Consultation Response from KC, Conservation and Design
2020/92307 Penistone Road/, Rowley Lane, Fenay Bridge, Huddersfield, HD8 0JS
Outline application for erection of residential development
Date Responded: 14/12/20
Responding Officer: Craig McHugh
Responding Ref: KB5/142
Summary

Figure 9: Viewshed from Viewpoint 3 from terrace of Woodsome Hall

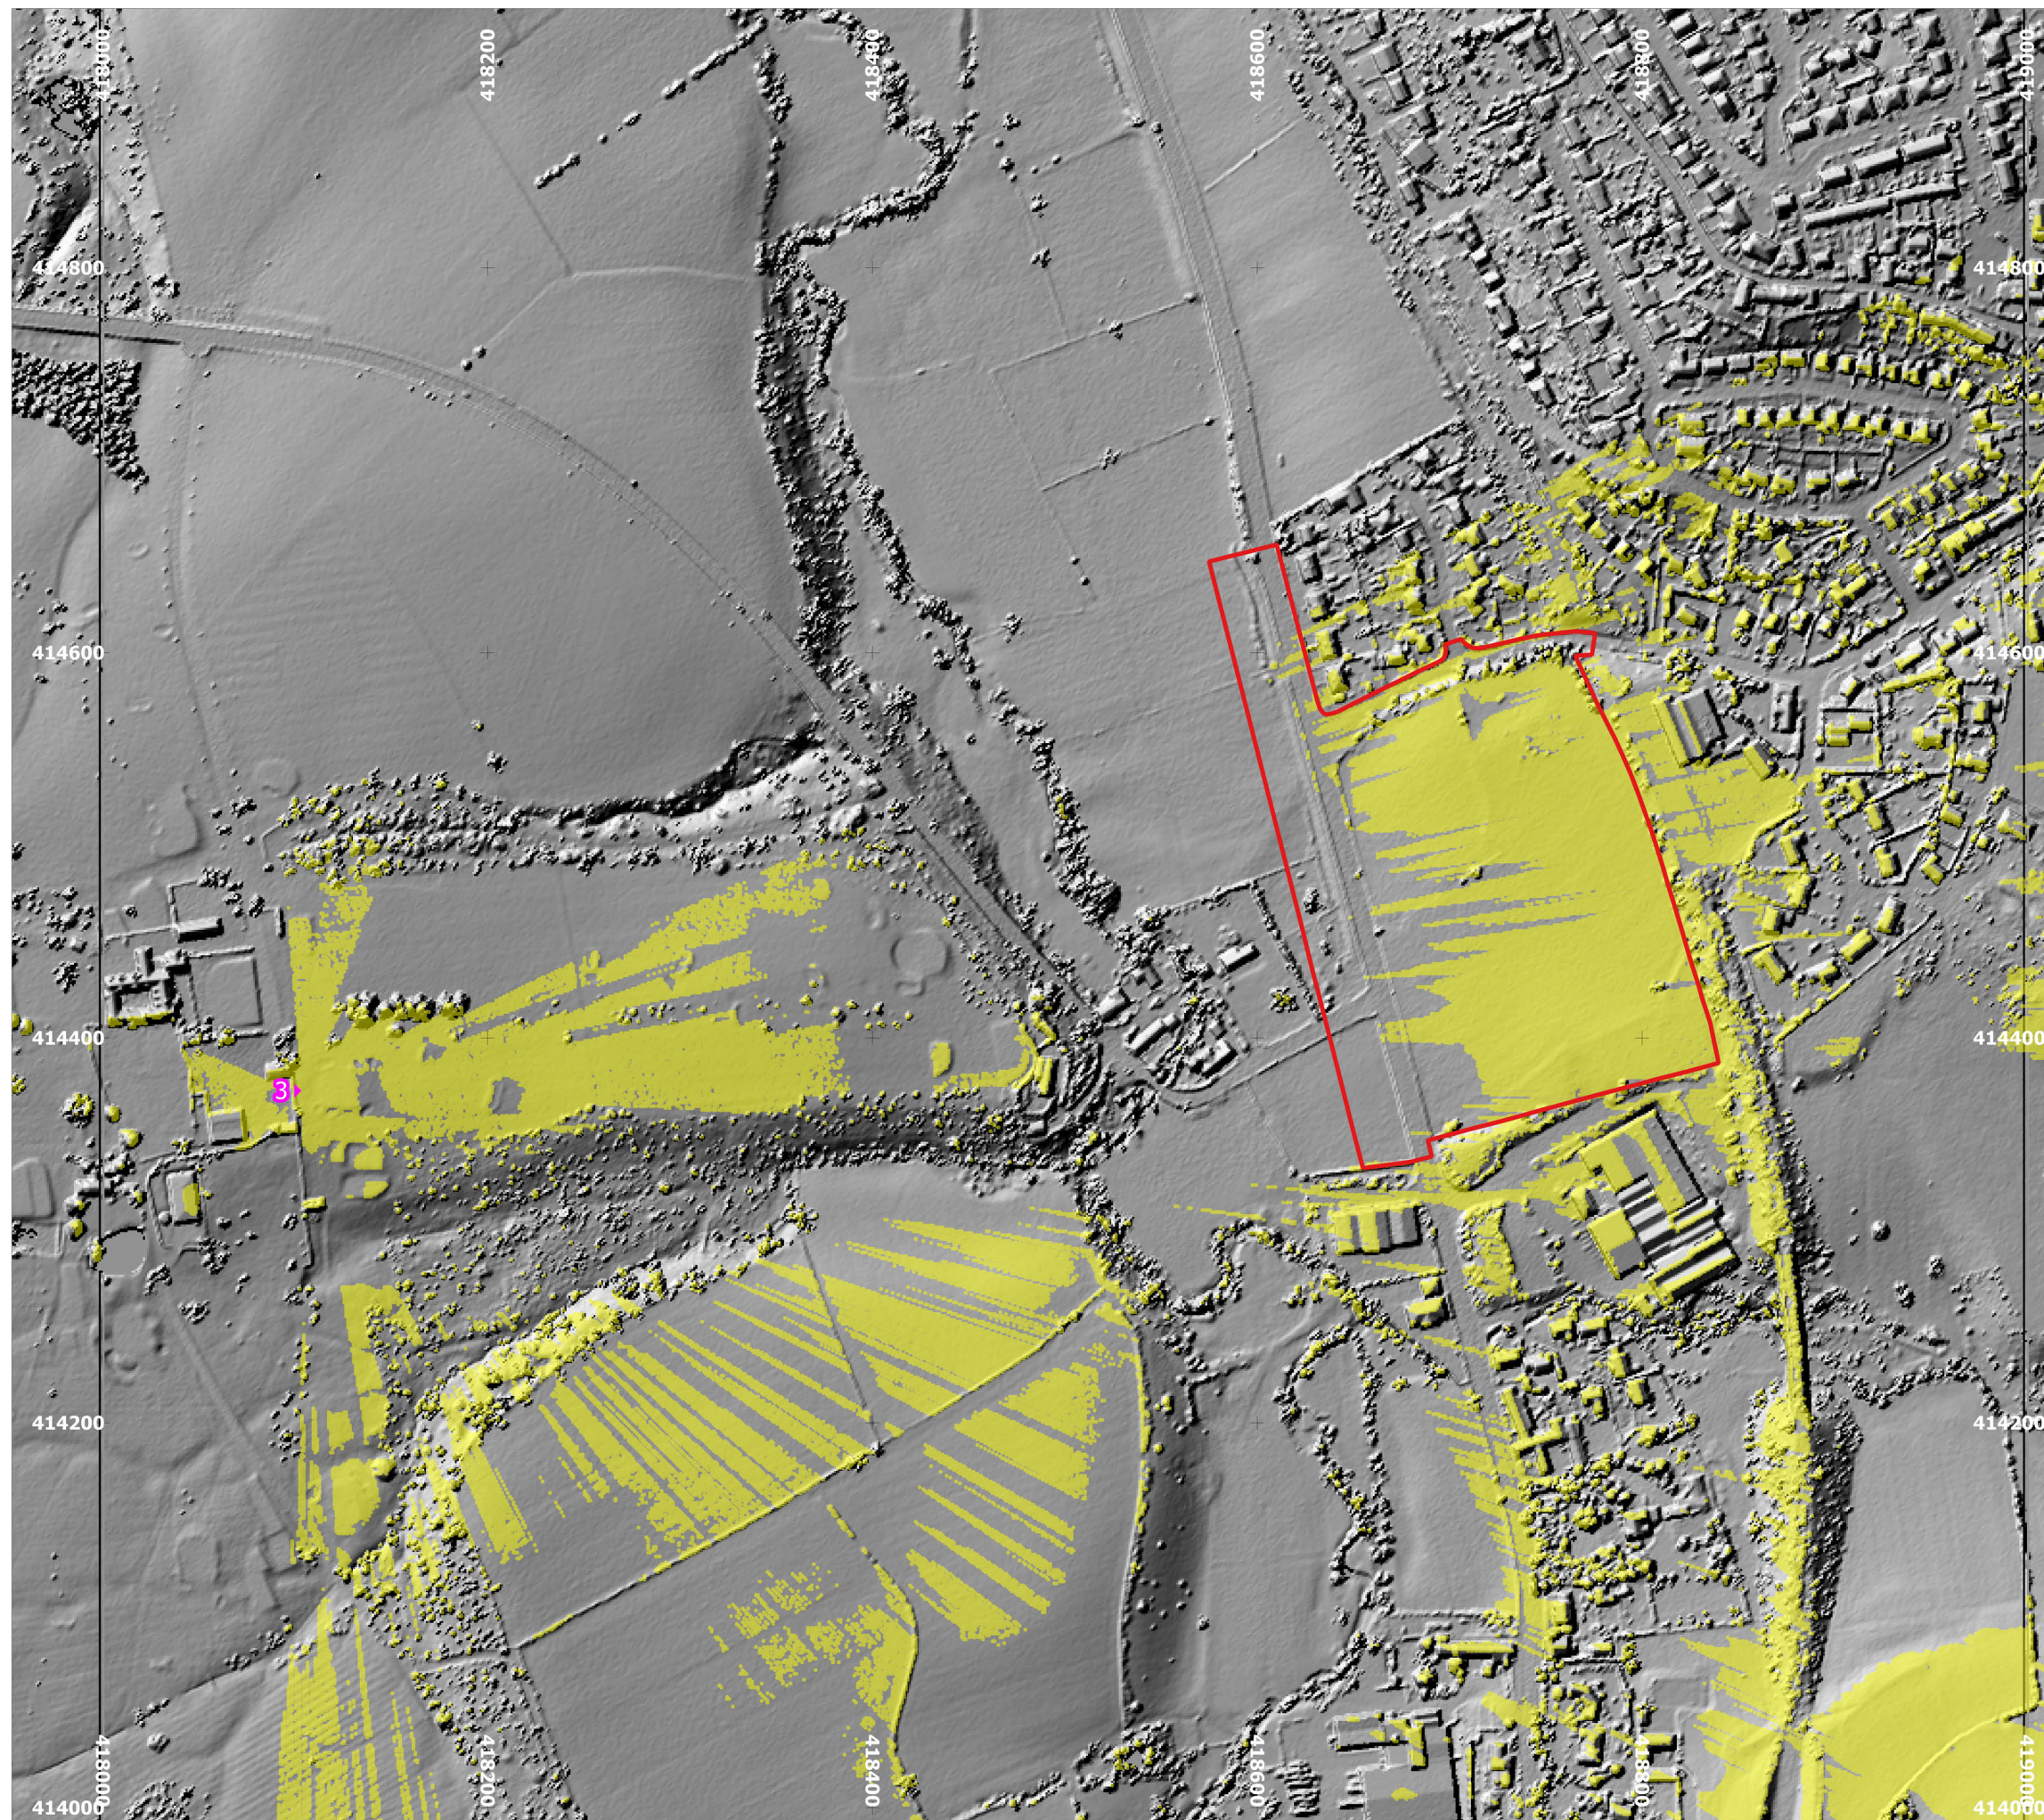
The application is accompanied by a heritage statement. This includes viewsheds and photographs from three viewpoints. These viewpoints are suitable for illustrating the impact of the development on setting of Woodsome Hall, specifically its terrace, lawn and parkland and surviving rural setting. They do not however include a visual impact assessment to adequately illustrate that impact, nor are they sufficient to evaluate the impact of the currently proposed road junction or the proposed housing development. Similarly, the Design & Access Statement appears to be rather ambiguous in terms of the extent of the proposed road networks and the integration of the main vehicular routes. Consequently, it is not possible to evaluate the impact on the character of the landscape or the designated heritage assets, or plan for adequate mitigation.
